**PROPOSED STRATEGIC HOUSING DEVELOPMENT  
'THE CONNOLLY QUARTER': DESIGNERS' RESPONSE  
TO QUALITY & ROAD SAFETY AUDITS**

**OXLEY HOLDINGS LIMITED**

**PROJECT NO. 0635**

**30<sup>th</sup> SEPTEMBER 2019**

Client:	OXLEY HOLDINGS LTD									
Project:	CONNOLLY QUARTER									
Title:	ACCESS LAYOUT ORIEL STREET AND SEVILLE PLACE									
Code	Originator	Zone	Level	Type	Role	Number	Status	Revision		
0635	OCSC	XX	XX	SK	C	0008	S2	P02		
Date:	12.11.18	Scale:	1:200	@ A1	Drn by:	JS	Chkd by:	PM	Aprvd by:	TH

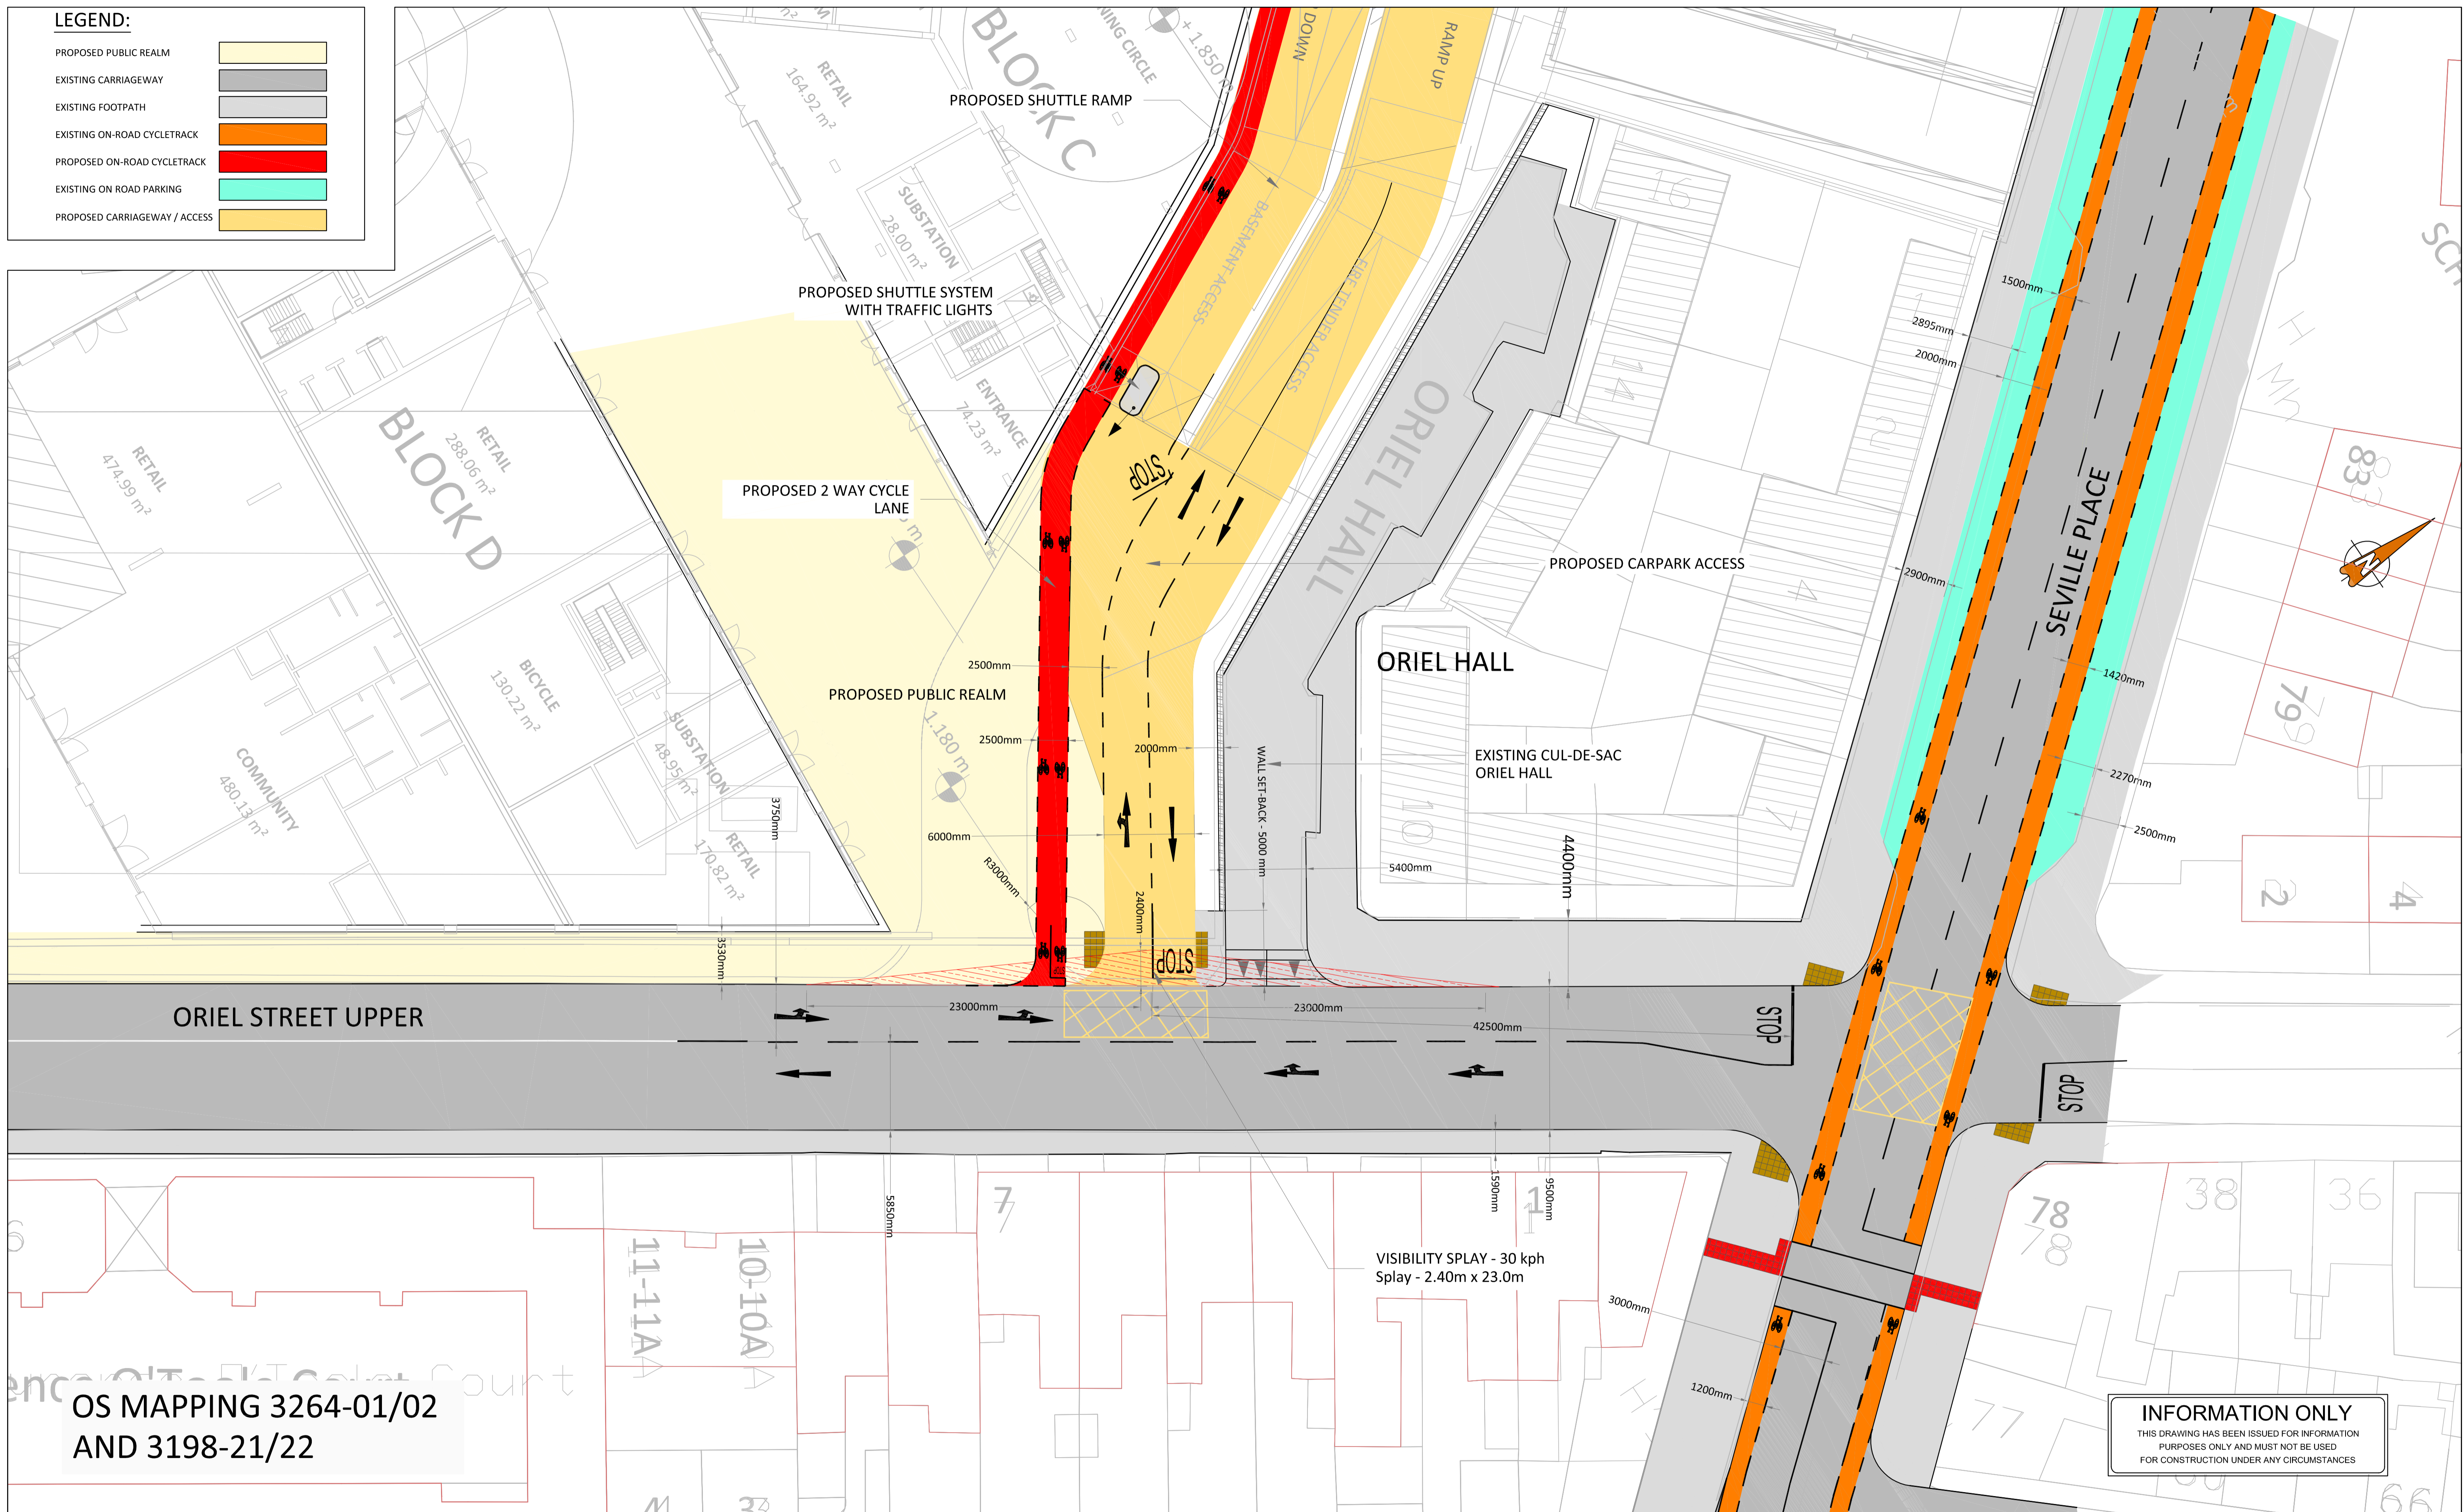
**Problem:** There is currently on-street parking on both sides of Oriel Street Lower. The drawing shows that parking will be removed on the development side of the street. This may lead to locals parking partially on the footpath if they do not have alternative parking facilities. This could lead to hazards for pedestrians and blocking of sightlines for drivers exiting the new development.

**Problem:** It is envisaged that the proposed development will attract cyclists from the Amiens Street direction that will travel south-west on Seville Place and turn right onto Oriel Street Lower. Currently cyclists have to enter the carriageway to turn right or travel to the toucan crossing on the opposite side of the junction. It is unlikely that cyclists would undertake the latter due to the extra journey time and the former would put them at greater risk of being struck by a passing motorised vehicle.

**Problem:** It was observed during the site visit that there is no buffer zone between parked on-street cars along Seville Place and the on-road cycle lane. A replica situation is presented in the drawing. This could lead to collisions between cyclists and opening car doors of parked vehicles or cyclists losing control as they swerve to avoid opening doors. The Audit Team acknowledge that there is limited road space available.

**Problem:** It was observed during the site visit that the cycle lanes along Seville Place are advisory only and are not operational between 7pm and 7am. These restrictions make it necessary for cyclists to share space with vehicular traffic which increases the risk of collisions between those road user groups. It is noted that the Seville Place cycle lanes lead to the Grand Canal/spencer Dock/Samuel Beckett Bridge Greenway. Continuity of dedicated cycle facilities would be beneficial.

**Response:** The applicants are satisfied to undertake a Parking Review locally as recommended. Oriel Street is 125 m long from Oriel Hall to Commons Street and accommodates 25 parallel parked vehicles on either side of the road along with some further vehicles between Oriel Hall and Seville Place. The sightline requirements for the proposed access will result in the loss of 5 no. spaces on the north side of the street i.e. about 10% of the on-street total. Off-street in-courtyard parking is provided for the DCC residential development on the southwest end of the site which will be unaffected by the development, as will the on-street parking on Oriel Hall. In that context the overall impact on on-street parking is considered to be minimal.

**Response:** The applicants are satisfied to work with the Roads Authority to investigate the traffic impact of any signalisation on the Seville Place - Oriel Street junction with a view to introducing a Toucan Crossing as recommended.

**Response:** The proposed development will bring about a net reduction in parking on the site from 425 spaces to 208 spaces. Traffic levels on Oriel Street are quite low as are roads speeds and neither will increase as a result of the proposed development. The designers are of the view that adequate footpath widths should be maintained in order to cater for the increased pedestrian flows that will be brought about by the development – particularly on foot of the reduced car park provision. In that context the designers are of the view that the current footpath width should be maintained. The issue of a cycle buffer will be raised with the Roads Authority.

**Response:** The designers and applicants concur with this recommendation and will raise same with the Roads Authority during the course of the planning process.
